Re: 24528/015 – Detached outbuilding comprising a double garage with home office/gym and games room and store contained in the roof space (amended plans received 20/7/22) at Crossways, Trinity Road, Bentworth, Alton GU34 5NN

Application for removal or variation of a condition following granting of planning permission.

Further to the granting of planning permission under planning application reference: 24528/015, dated 23 August 2022, please find enclosed an application for a Section 73 amendment to planning condition 5.

**PROPOSED NORTH WEST ELEVATION**  
SCALE 1:100

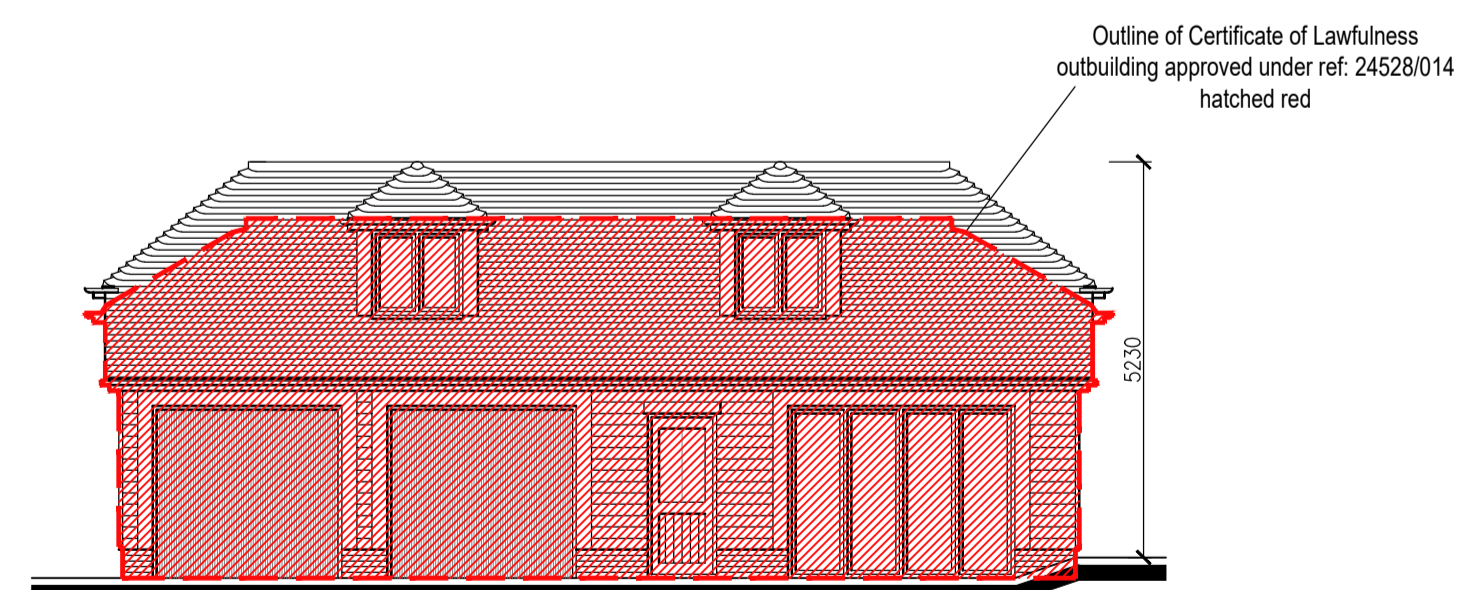
It is also proposed that a single rooflight be added to the north west elevation.

**PROPOSED SOUTH WEST ELEVATION OVERLAY**  
SCALE 1:100

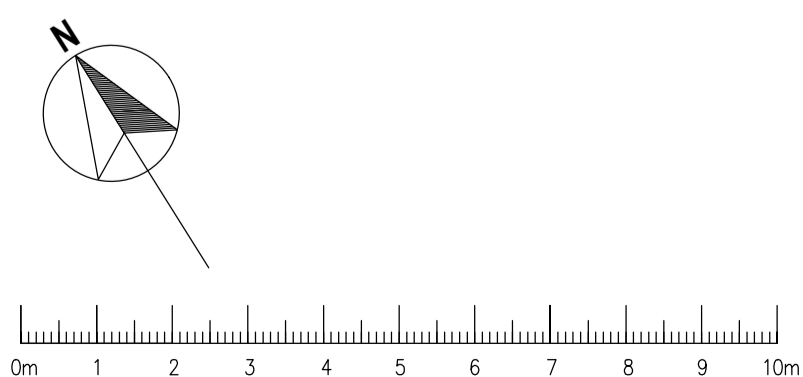
The applicants would like to make a minor change to the approved outbuilding to remove the rooflights on the south west elevation and incorporate two small dormers in lieu of the larger triangular dormer.
